**Subject: Report Addendum and Response to City's Comments  
27th Street Short Plat  
7239 Southeast 27th Street  
Mercer Island, Washington 98040  
RGI Project No. 2016-120**

References: 1. The Riley Group, Inc, Geotechnical Engineering Report, 27th Street Short Plat, dated August 17, 2016.  
2. Topographic Survey by Site Surveying, Inc. dated January 18, 2016  
3. Site Plans prepared by Core Design dated September 12, 2016

As requested, The Riley Group, Inc. (RGI) is responding the review comments from the City of Mercer Island, prepared by Will Piro dated October 10, 2016.

7239 SE 27TH STREET SHORT PLAT

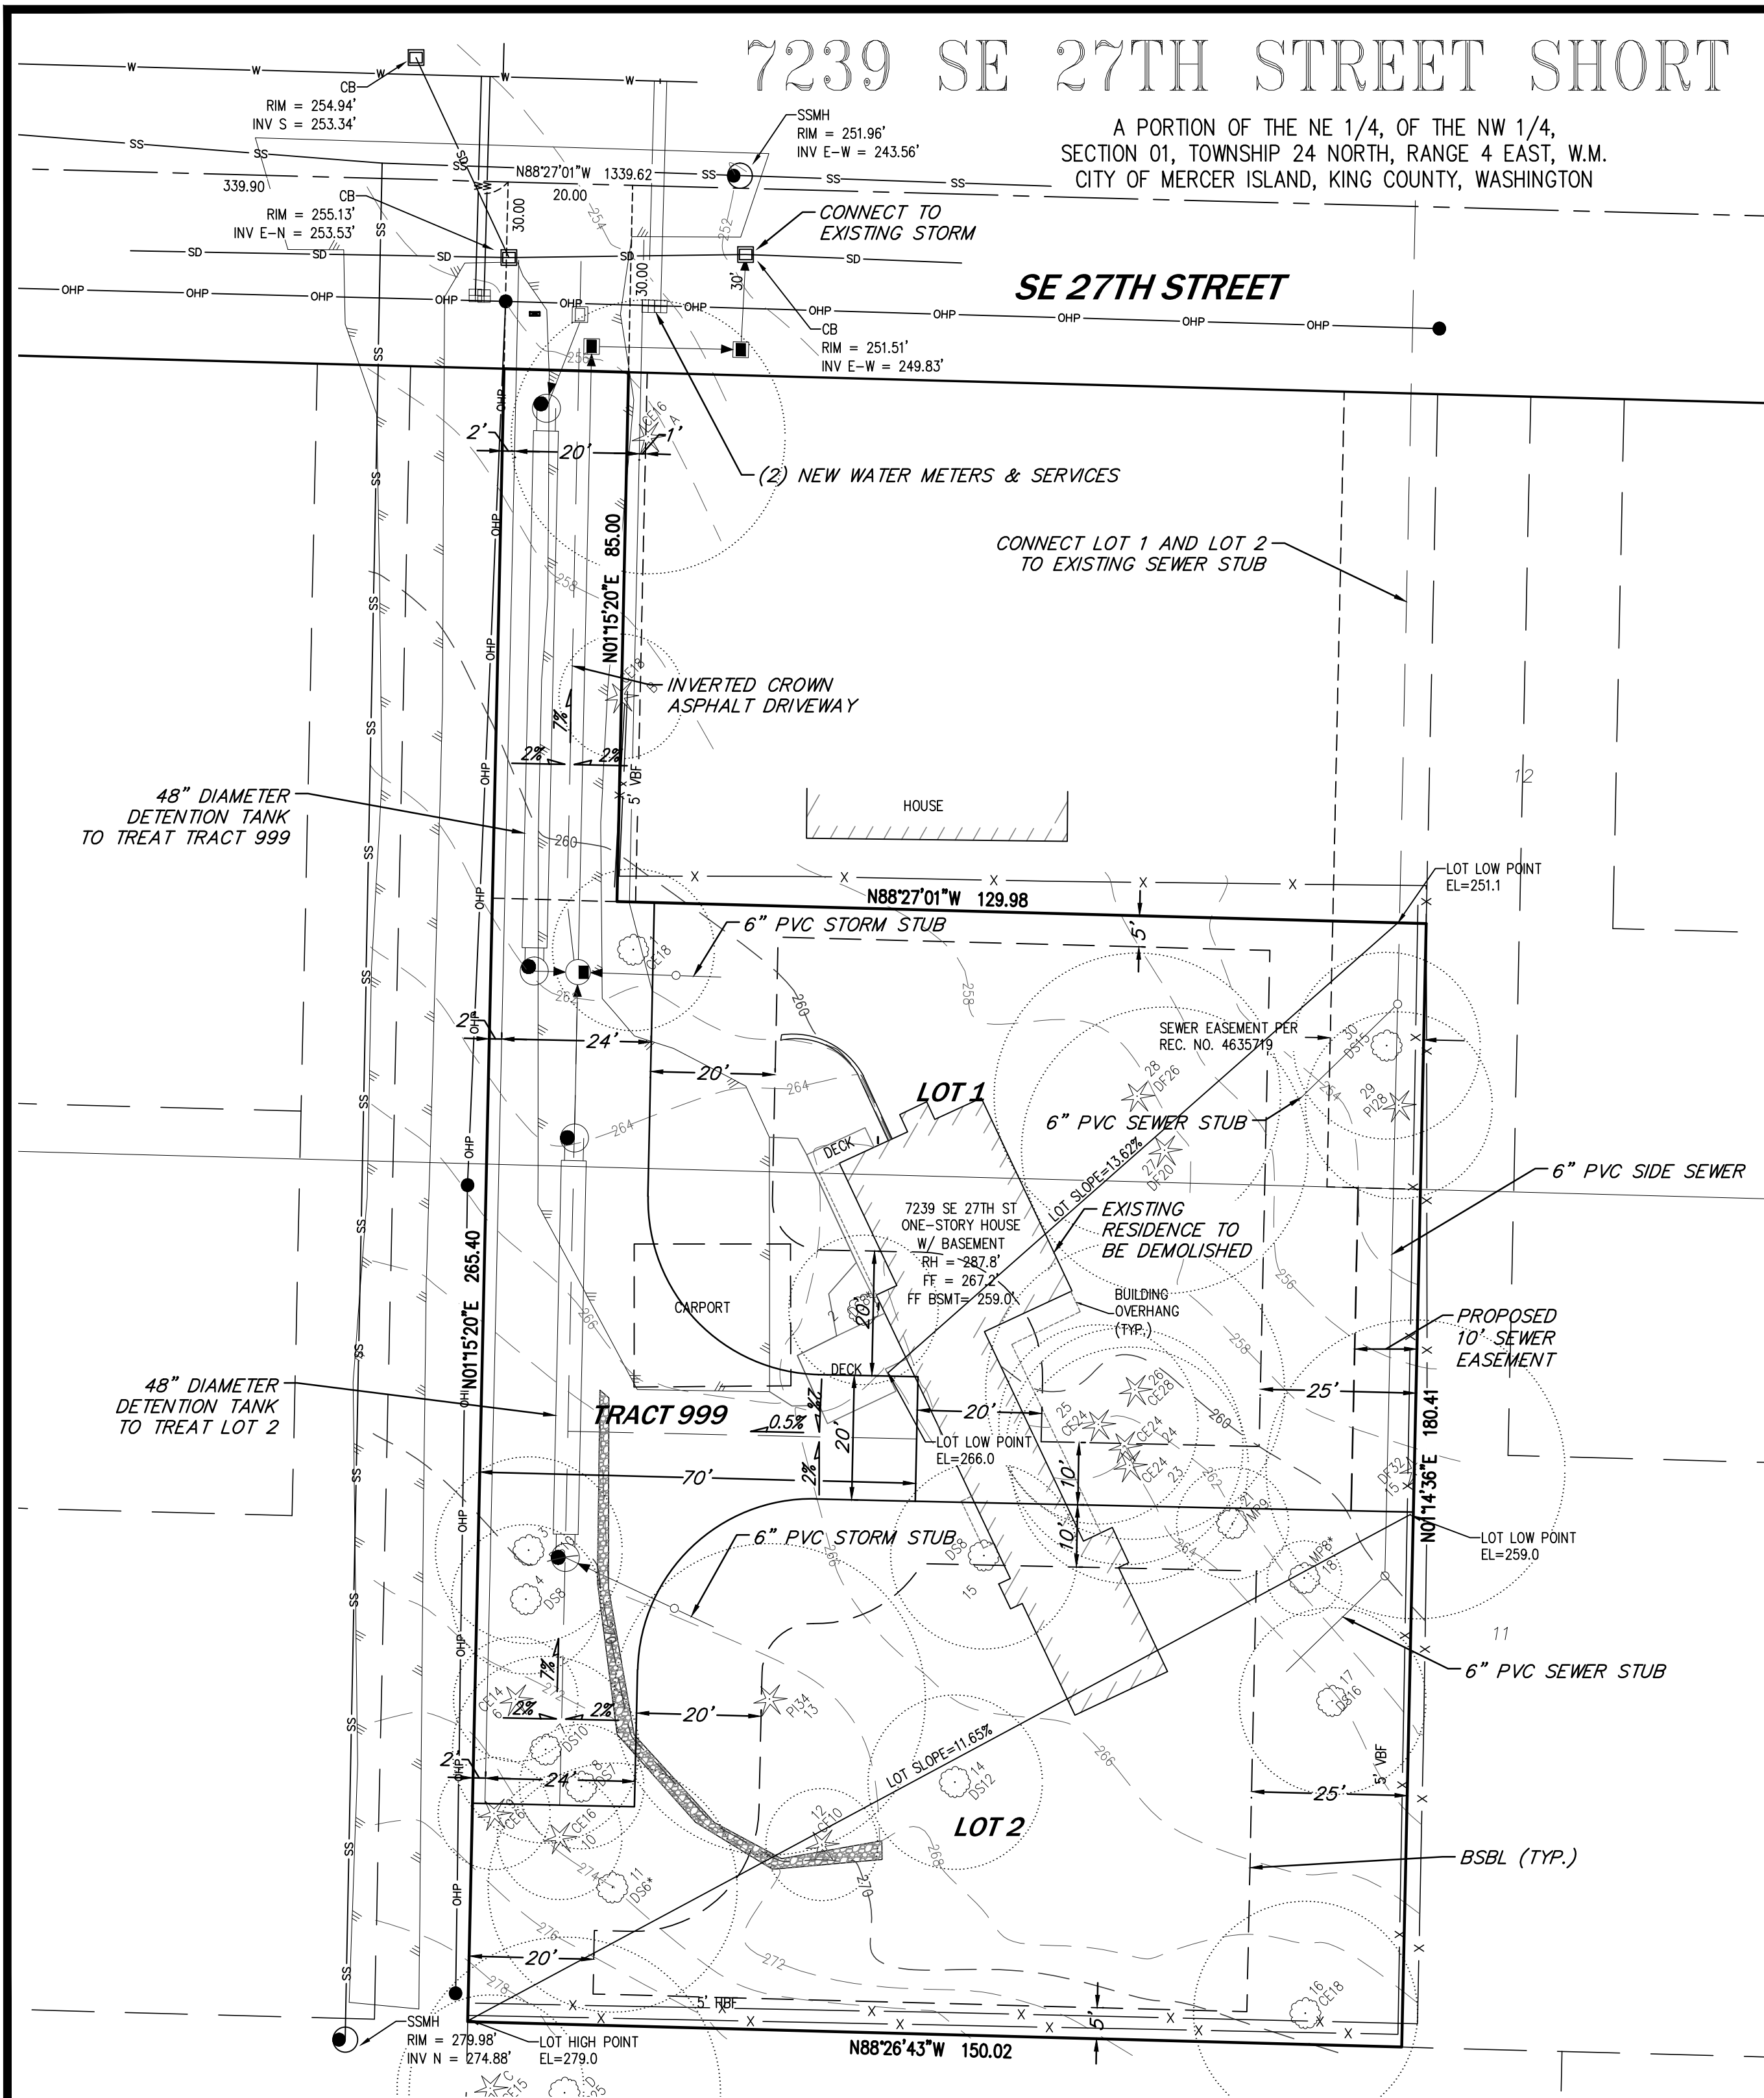
**Question:** *The geotechnical engineer's analysis must, using the definitions in MICC 19.16.010, demonstrate that the proposed building pad will not be located within the erosion hazard area.*

**Answer:** RGI reviewed the City of Mercer Island Municipal Codes (MICC 19.16.010(E)). The review indicates that a narrow area along the eastern property line is mapped as geologic hazard area of both soil erosion and landslide.

On August 2, 2016, RGI performed a site reconnaissance to evaluate the area along the eastern property line. During our field observations, we did not find any steep slope or indications of landslide or history of ground movement. Based on our observation, the potential of landslide along the eastern property line does not exist.

RGI reviewed the Web Soil Survey by National Cooperative Soil Survey. The major portion of the site is mapped as Kitsap silt loam, 2 to 8 percent slope (KpB). Runoff is slow to medium, and erosion hazard is slight to moderate. The southwest corner of the site is mapped as Arent, Alderwood material, 6 to 15 percent slope (AmC). Runoff is medium and the erosion hazard to moderate to severe.

Based on our review the current design, our boring logs and the contours; only small portion of the building pad on the south side of Lot 2 exceeds 15 percent slope. Most of the site has a moderate erosion hazard. The erosion control measures provided in our referenced report, if incorporated into the project design should be adequate to control erosion on the site. Based on the soils encountered and the slopes on site, the development will not increase the potential of soil erosion on the site or on adjacent sites if the recommended erosion control measures are implemented during construction.
